Application number: 2023/90444	
What is the application for?:	Erection of detached dwelling
Address of the site or building:	Land adj, Fern Bank, Far End Lane, Honley, Holmfirth, HD9 6NS
Postcode:	HD9 6RP

Type of comment: An objection	
Do you wish your comments to be published on the website anonymously?	Yes

| Drawing No.<br>3479 (0-) 05                                               | Revision<br>D                  |

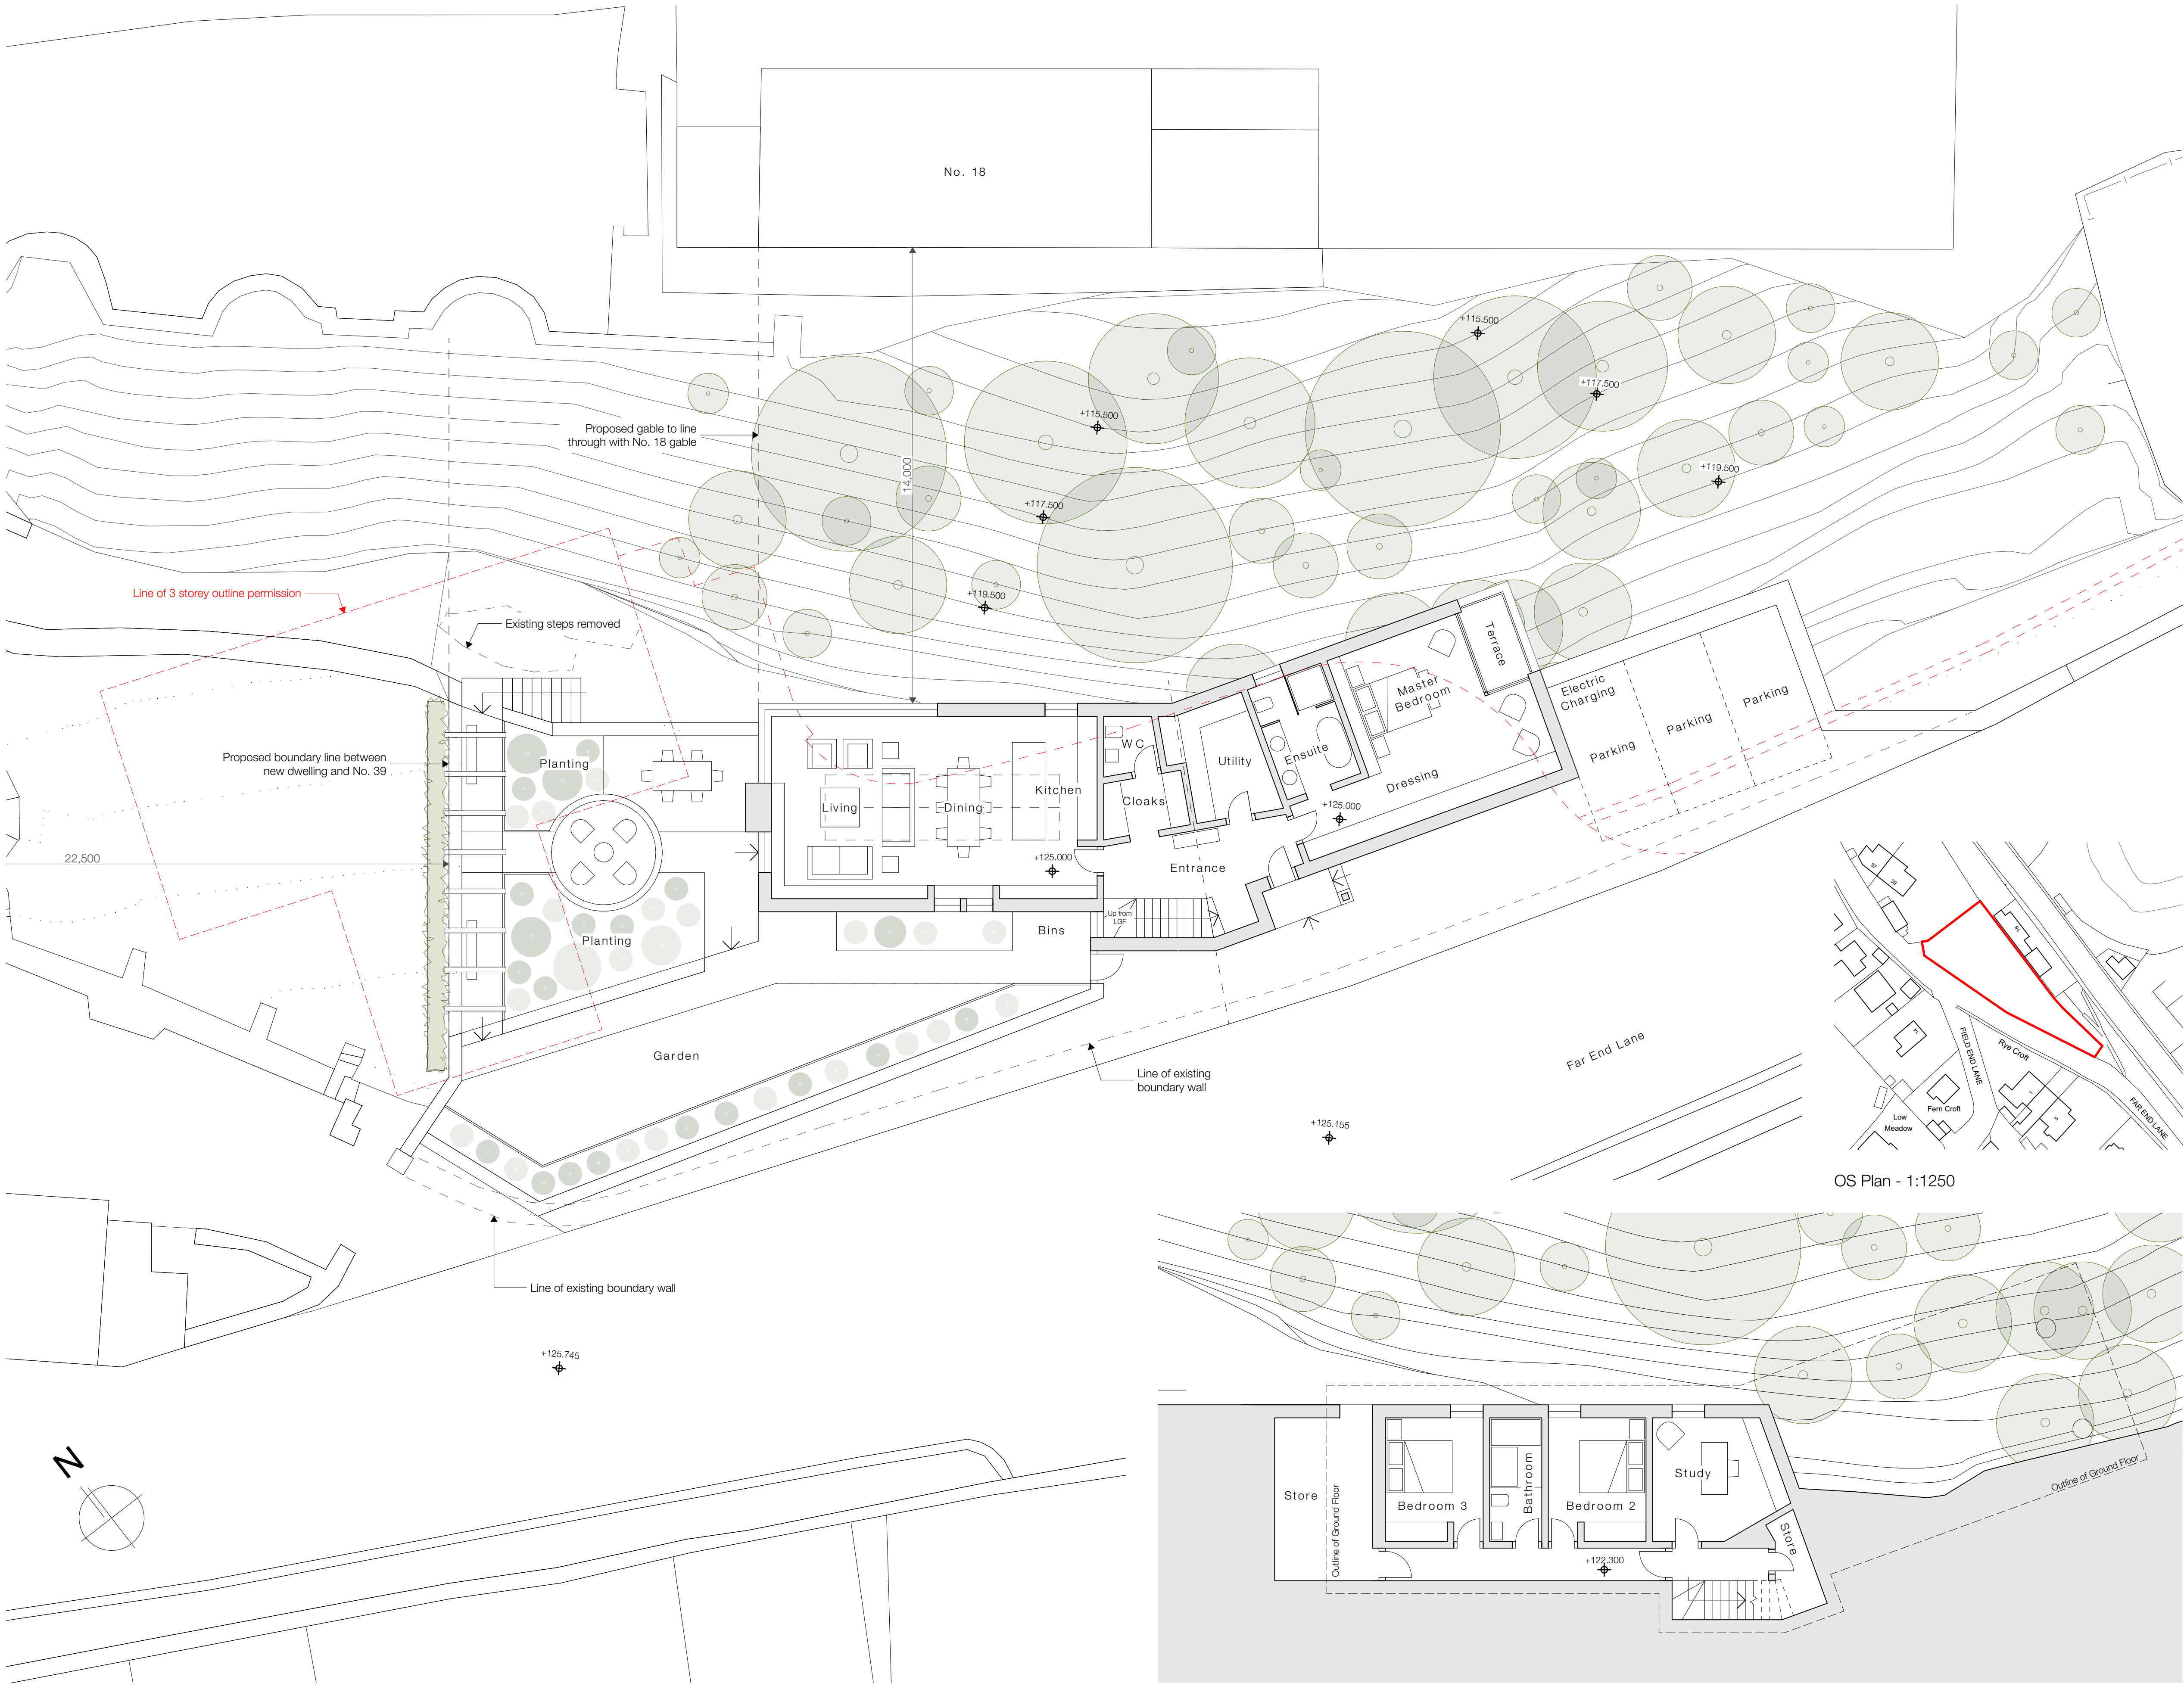
The updated elements of the application are not clearly explained, but it looks like the applicants now propose that their parking spaces are moved further along the frontage, further away from Honley village, presumably in an attempt to deal with Highways concerns.

Health and safety – risk of road traffic accidents - the adjusted location for the car parking spaces is in my view simply ‘moving the deckchairs’, and there remain substantive risks given the volume and speed of traffic travelling in both directions, and particularly from Honley village around the blind bend. Also, I note that drivers using the spaces would need to reverse out onto or into Far End Lane, leaving them as a sitting duck for traffic. As for the report undertaken by HDC Support Limited, please can you confirm who instructed and paid for this report – was it the applicant by any chance?! I am startled by their assessment of traffic volume and speeds which are based on a 2 hour sample at mid-morning times and which, as a local resident, do not seem to match with reality. People are also forgetting the increased volume of traffic generally locally being generated by the new Miller Homes development for example and more ‘rat running’ is inevitable.
